CITY OF ALBUQUERQUE

**RE: 1424 Caballero Drive SE
Grading and Drainage Exhibit
Stamp Date 8-4-2016 (File:M23D008A)**

NEW CONSTRUCTION
GRADING AND DRAINAGE

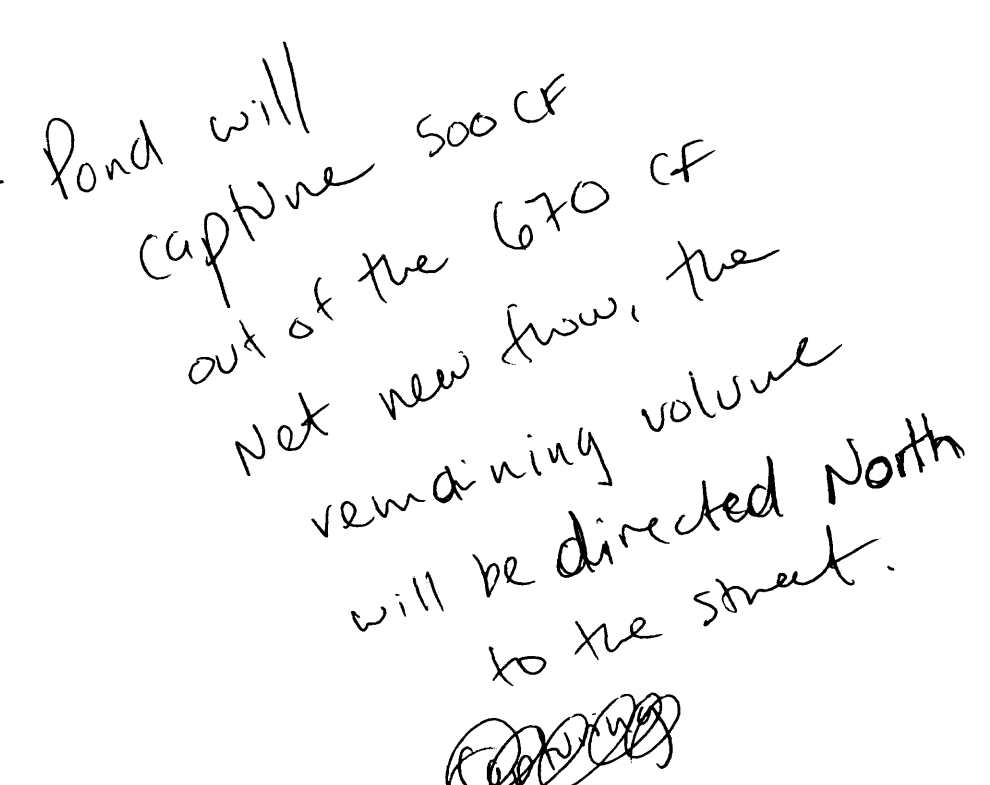
Based on the exhibit, we understand that a small pond is planned at the southern corner of the lot. This pond appears to only capture a portion of the additional runoff generated by the site, and it is unclear if the peak discharge is mitigated. However, based on the proposed retaining wall elevation and the swale shown, the remaining runoff appears to be directed to the street. Please contact me if this is not the case.

Please also ensure that this concept is maintained through construction. If this general condition is not possible during construction, a submittal will be needed to show how the discharge will be handled without increasing the historical overflow into the adjacent property.
